Environmental Health Division
1675 W. Garden of the Gods Road
Suite 2044
Colorado Springs, CO 80907
(719) 578-3199 *phone*
(719) 578-3188 *fax*
www.elpasocountyhealth.org

McConnel Minor Subdivision, MS-18-003

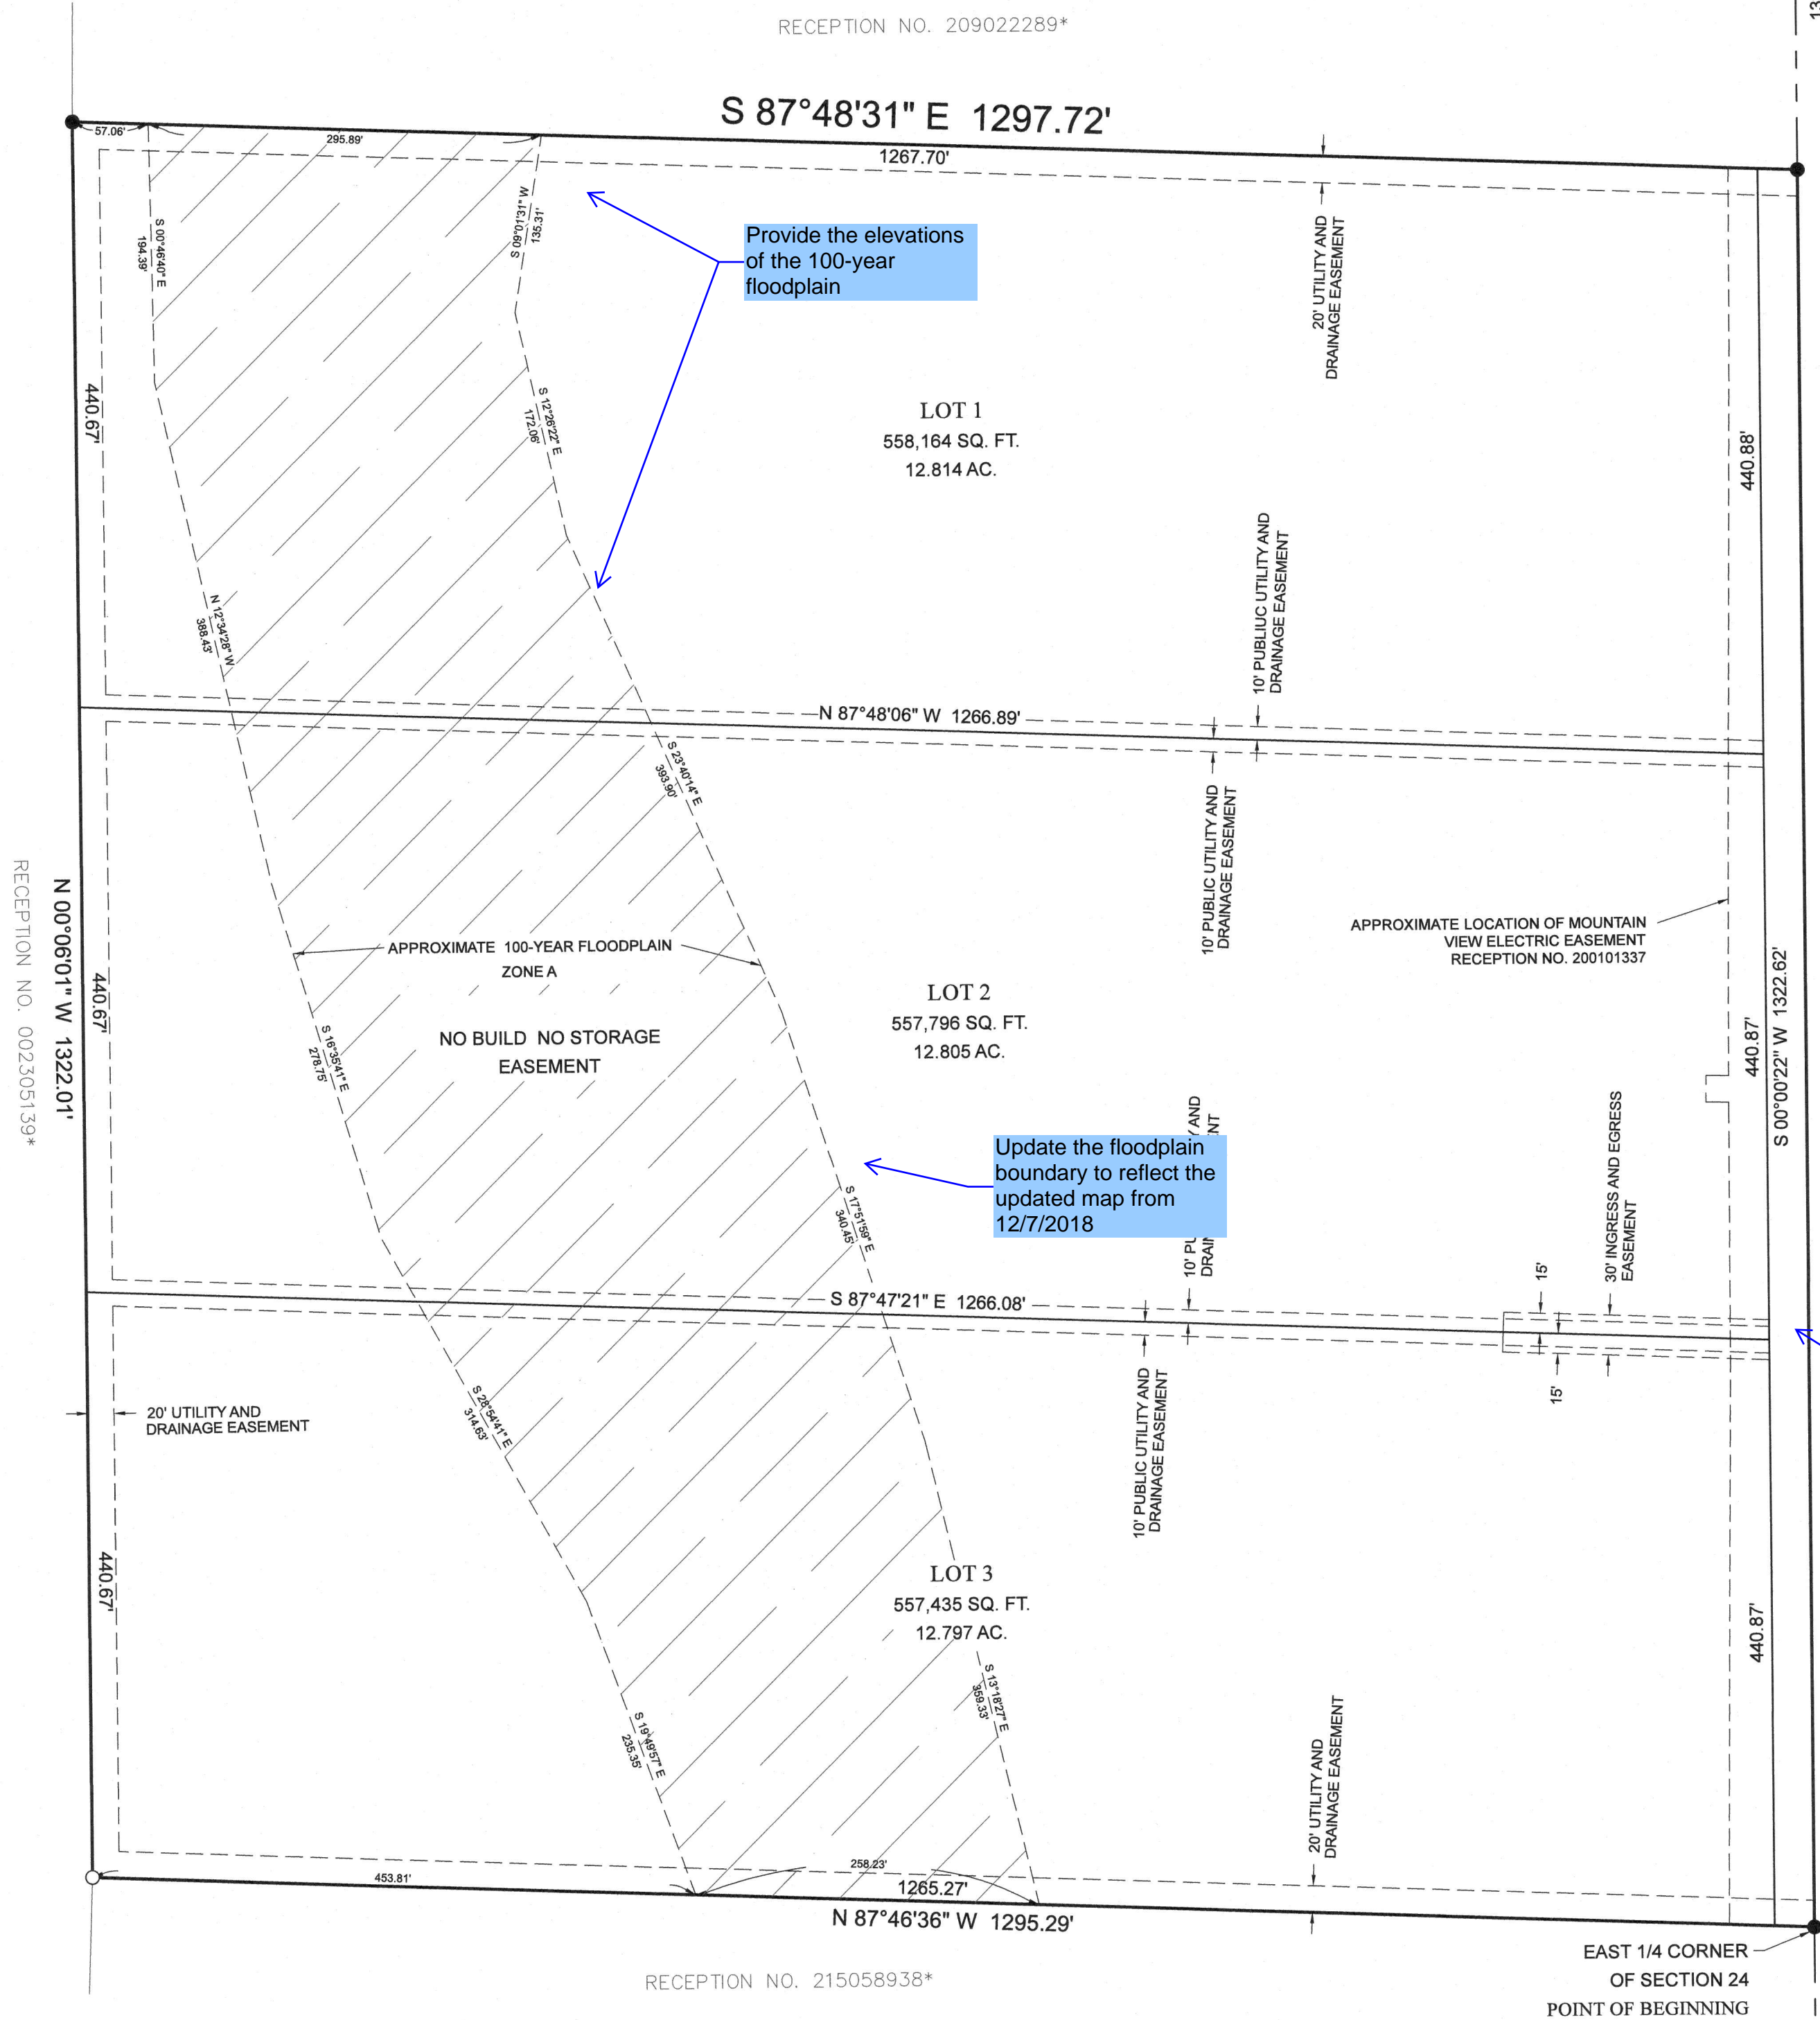
- Proposed new Lot #1 has an existing house and provided wastewater treatment by a permitted and approved onsite wastewater treatment system (OWTS) installed in 2002. The existing soil treatment area (STA) for this OWTS must be 10' minimum from any new proposed lot line. There is also a requirement for sufficient areas to be dedicated for the replacement of this STA should the original area fail requiring an addition or total replacement. The primary and secondary STA's (existing and proposed) must be protected from compaction associated with vehicles and/or livestock.

- The existing well and any new well must be 100' minimum from any existing or any new STA.
- Proposed new, undeveloped Lots 2 & 3 require full compliance with the El Paso County Board of Health Regulations, Chapter 8, Onsite Wastewater Treatment Systems.
